# Kiltiernan SHD

## Lands at Wayside, Kiltiernan

Quality Audit

Liscove Ltd.

BIN STORE & BICYCLE STORE TYPE 1

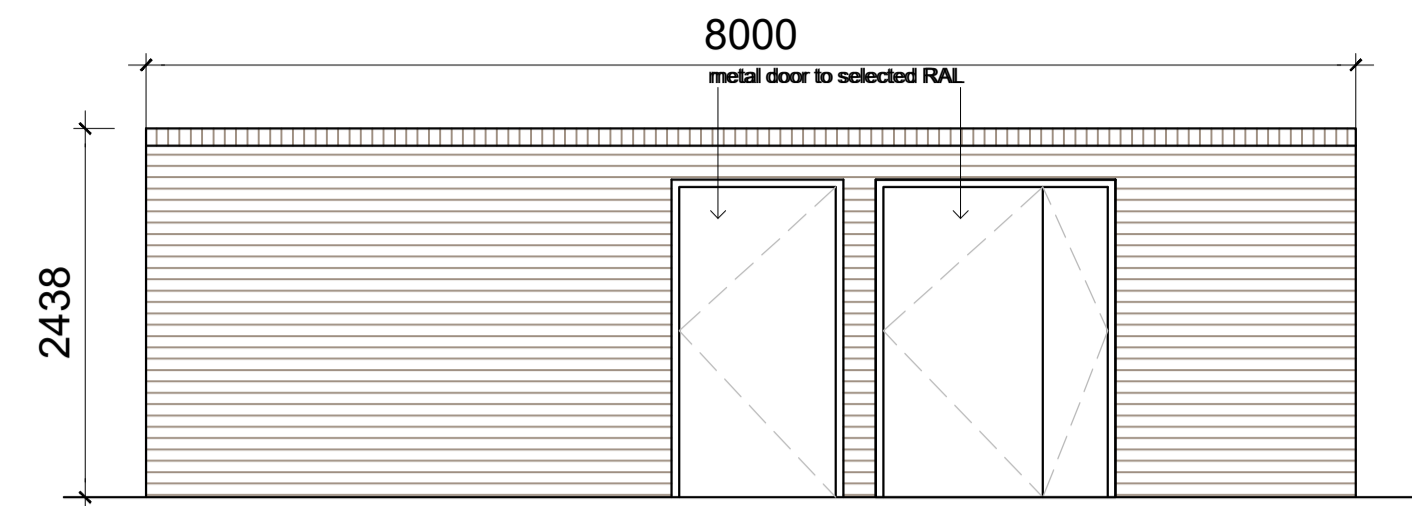
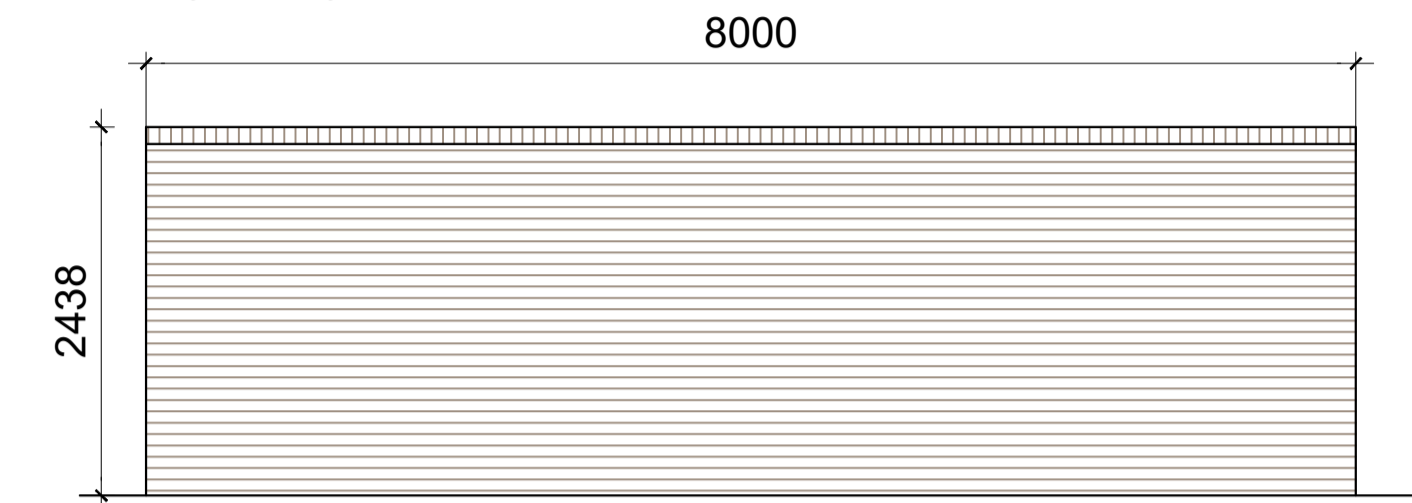
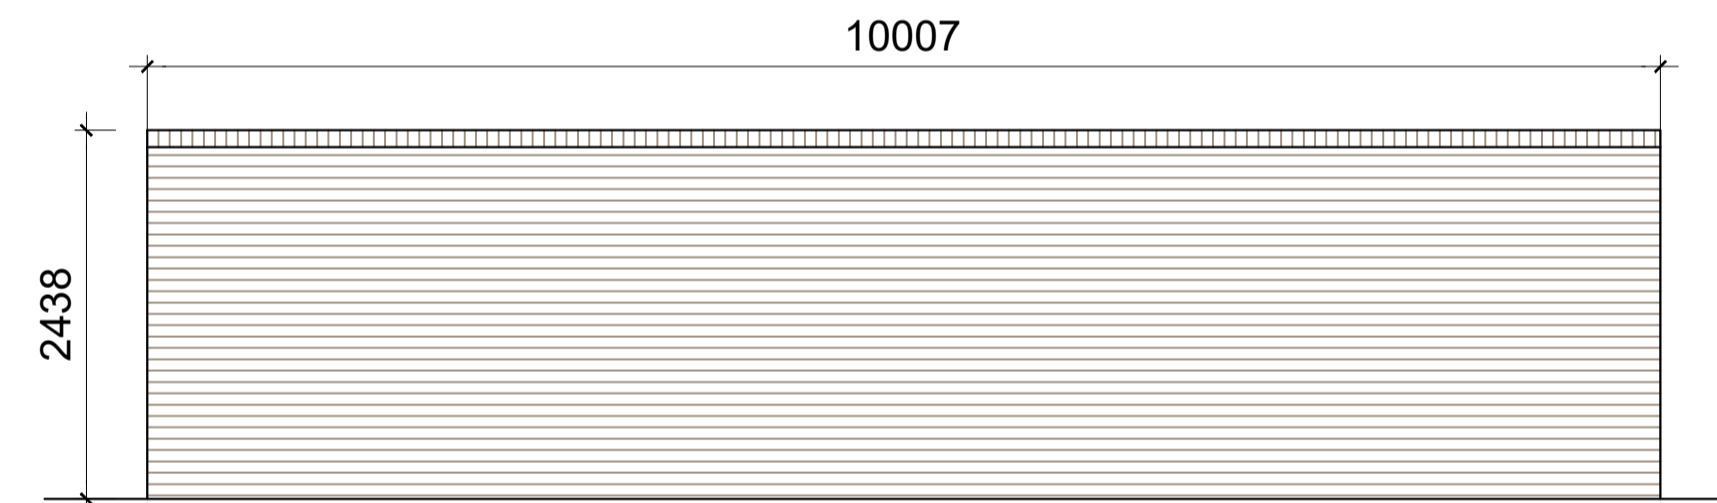
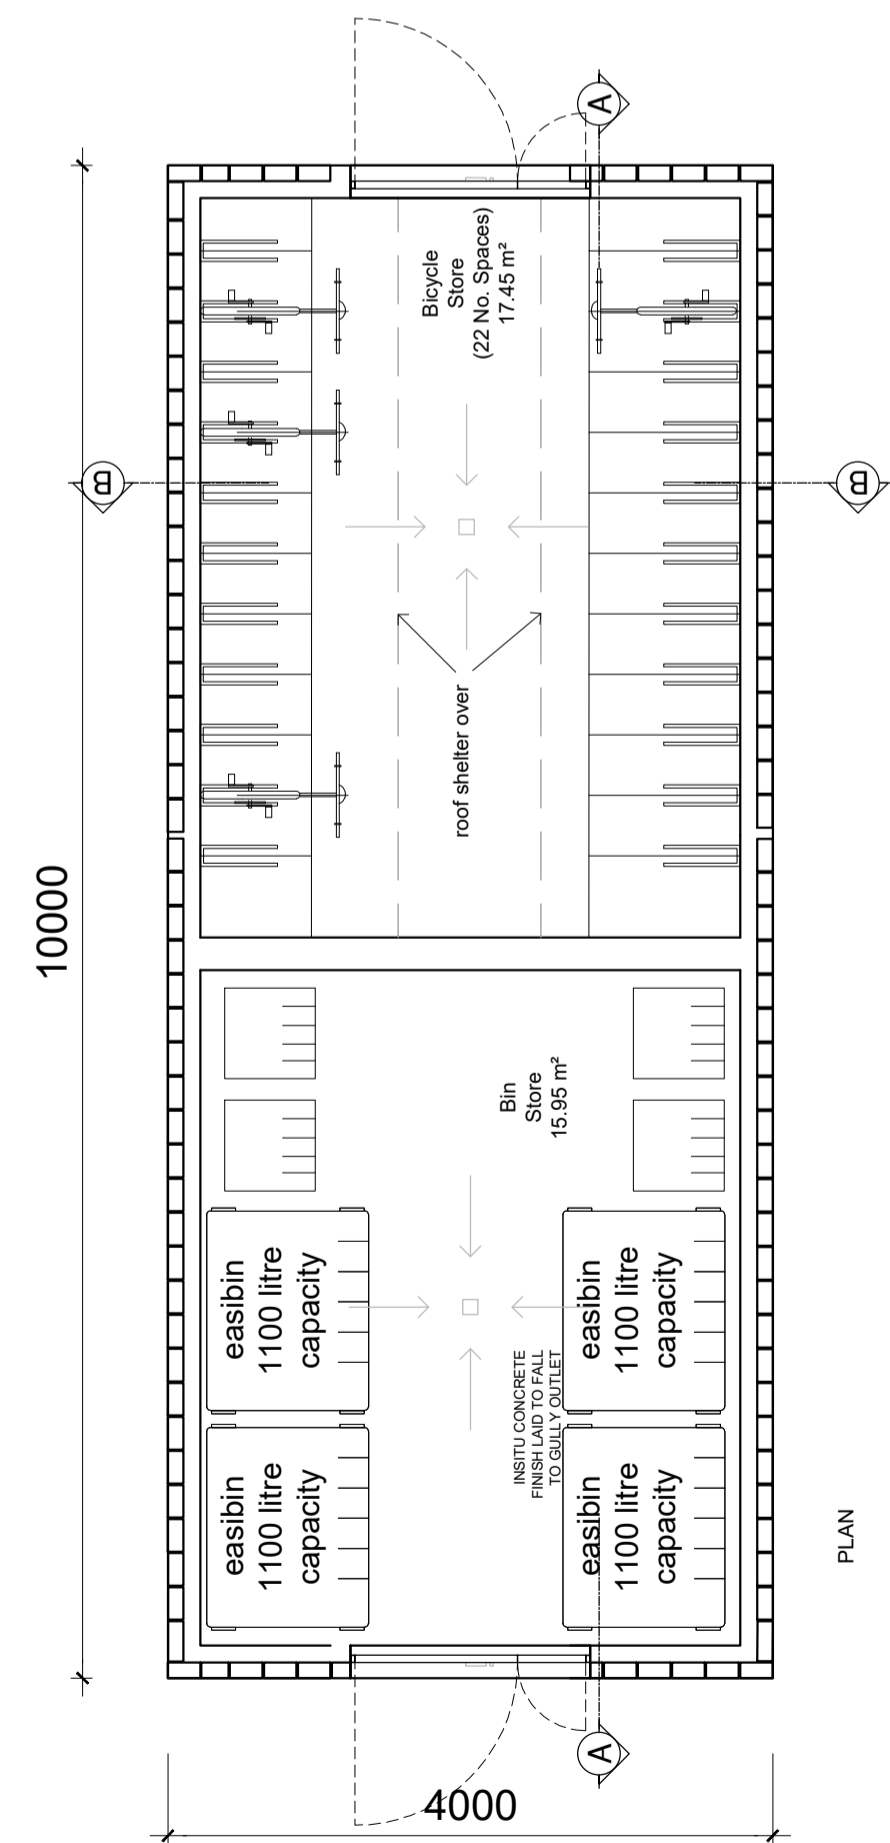
The proposed bin store is located in what appears to be remote of the proposed residential and commercial properties. This naturally increases the difficulty for people to access this area.

The Designer should assess the viability of having the bin store closer to the properties and reduce the need to cross the junctions and roads to access the store.

2.3.2	Y	Y	Location of bus stop facility provided on updated drawing.	
2.3.3	Y	Y	Bike and bin storage area is located in optimal location is shown based on available space, proximity to user sand frequency of uses.

JUNCTION No. 8
23m VISIBILITY SPLAY (Y)
2m SET BACK (X)

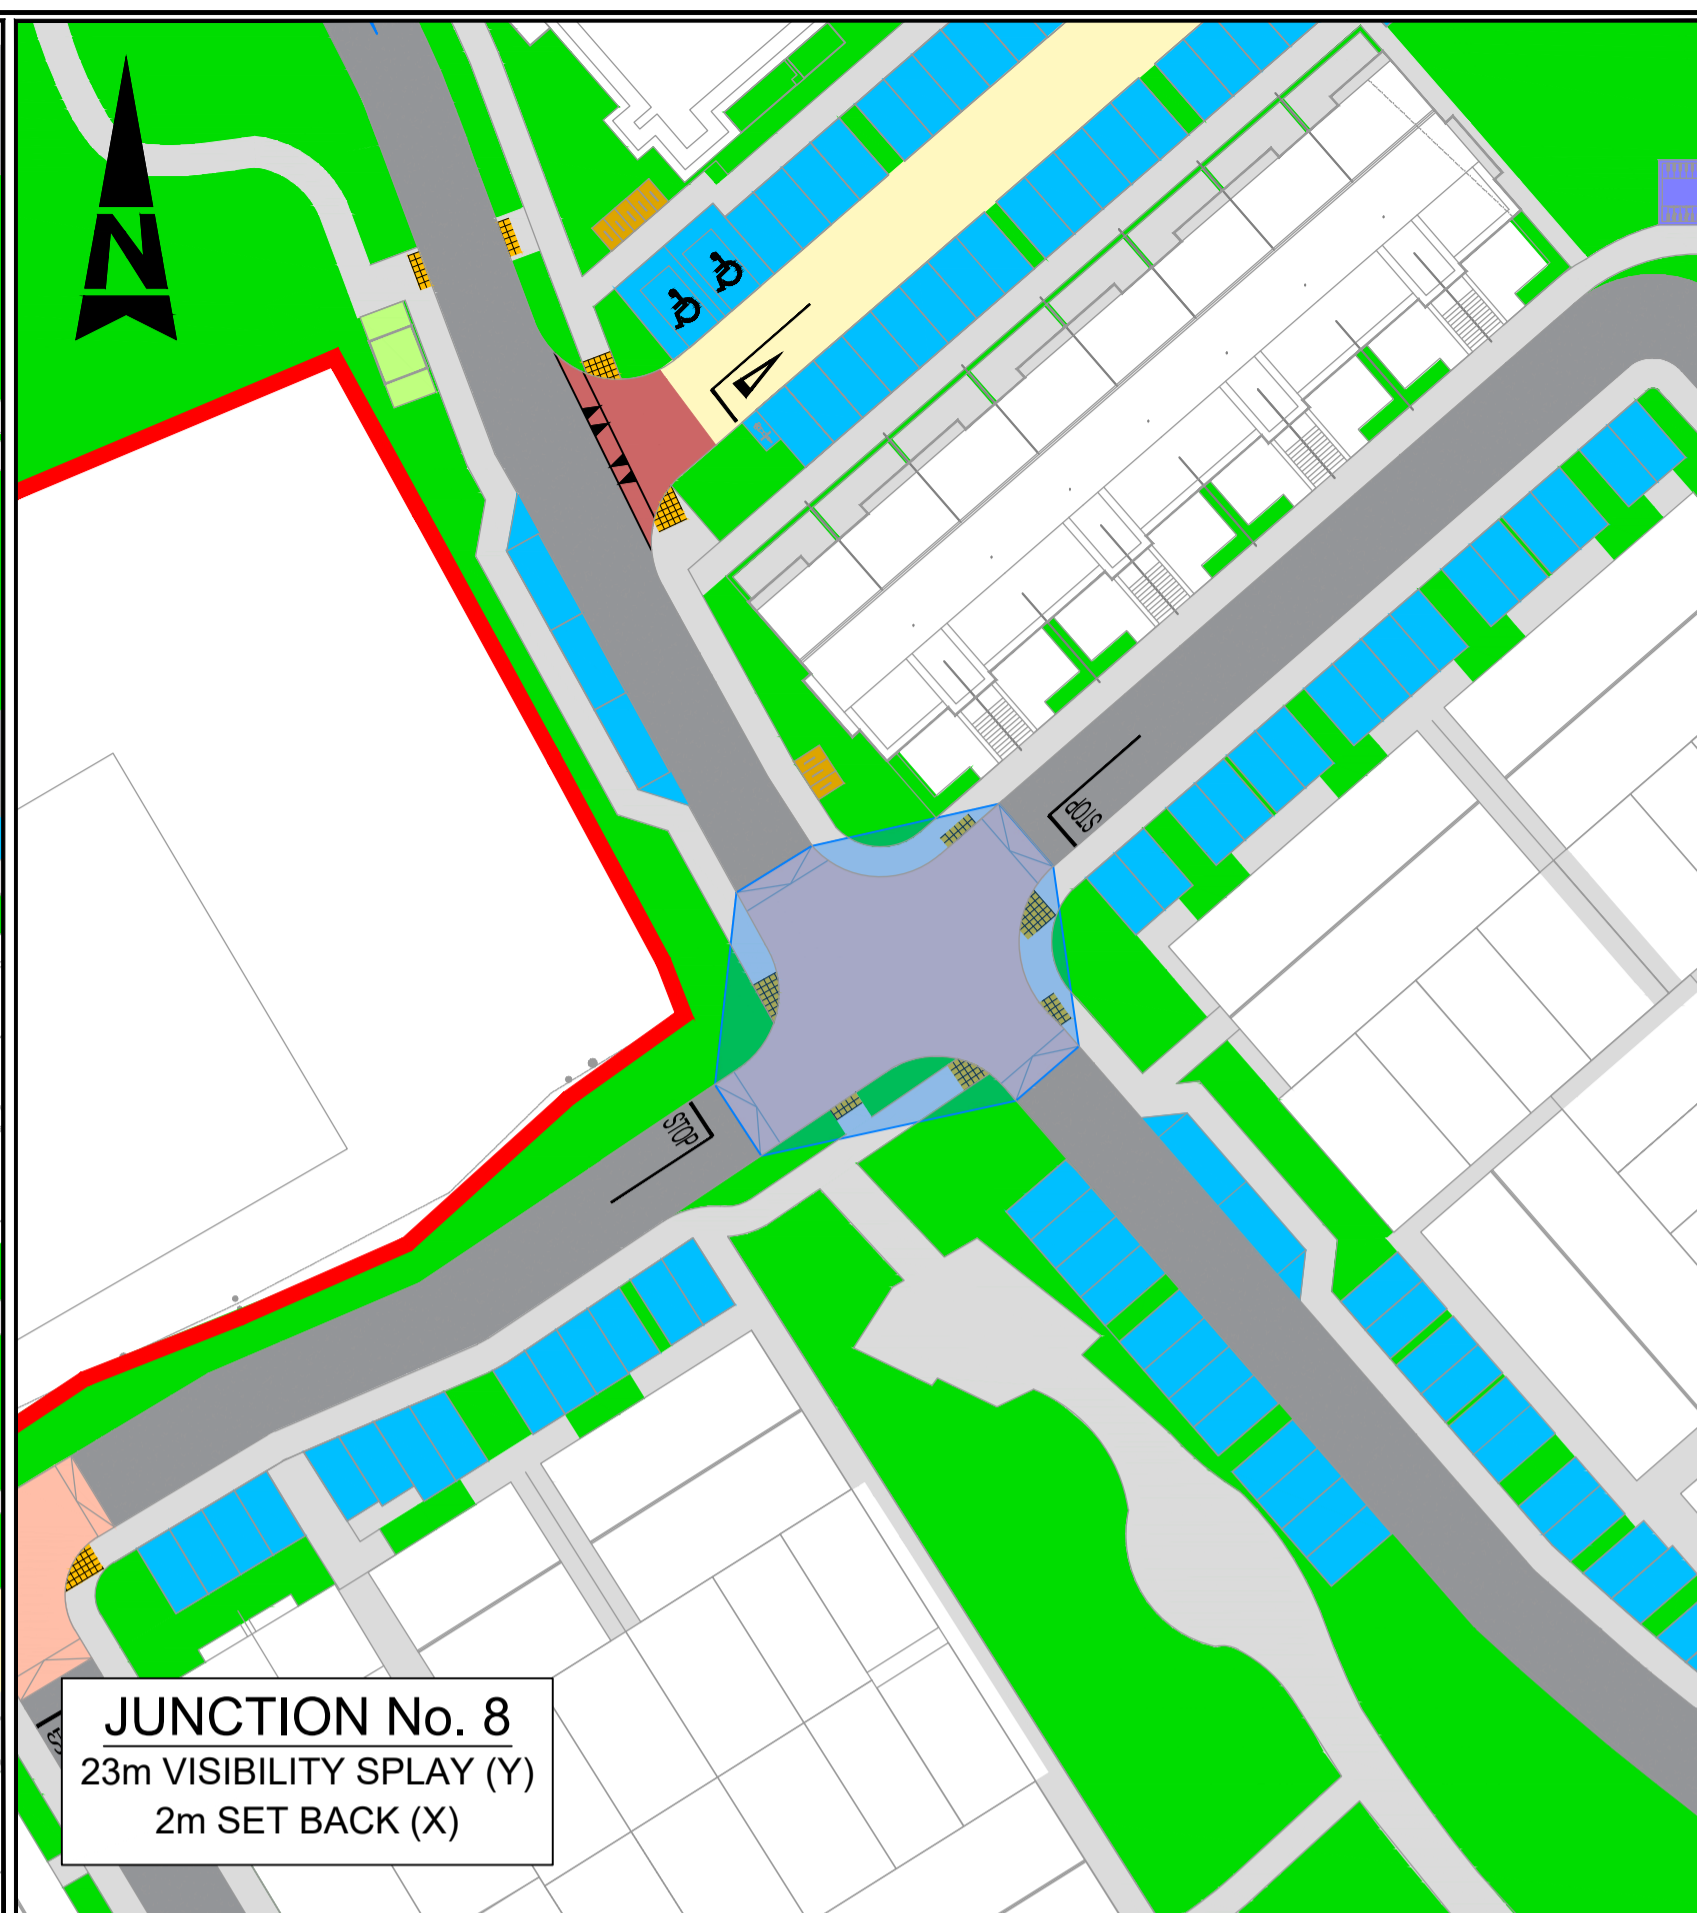
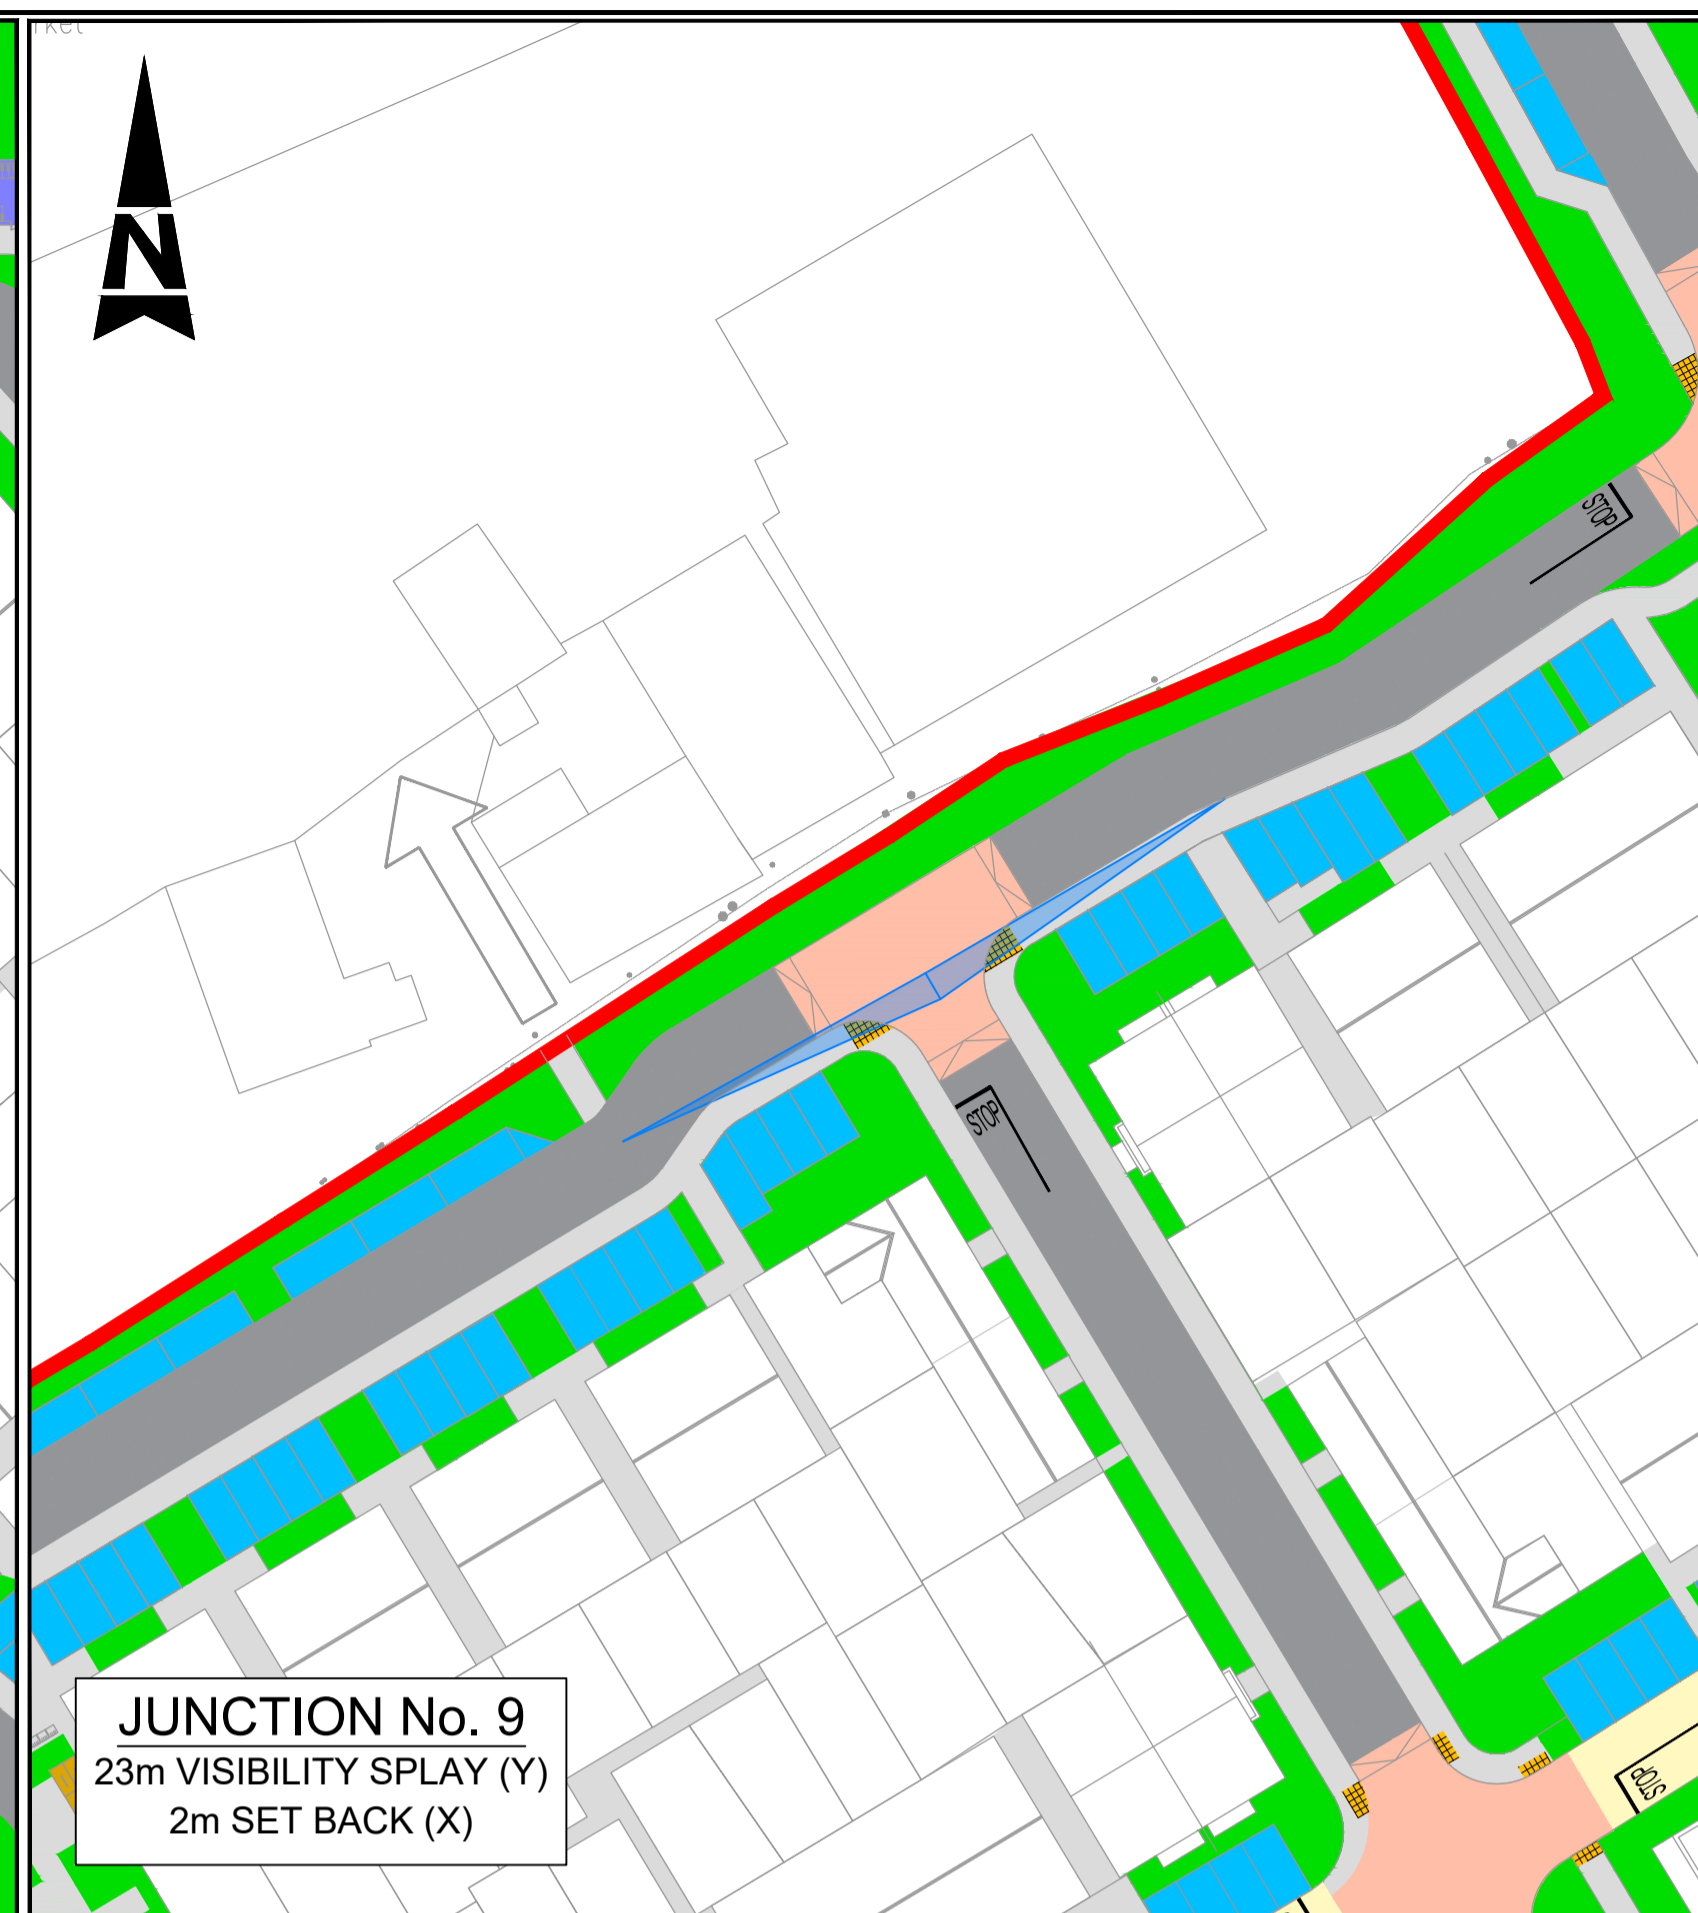
The north-south alignment includes a relatively sharp change/kink. Drivers may find it challenging to negotiate the junction and opposing traffic with the degree of stagger indicated. This may lead to conflict such as swipe and head-on collisions.

The Designer should review the extent of stagger proposed and allow a smoother movement of traffic in the 'main' north-south flow of traffic.
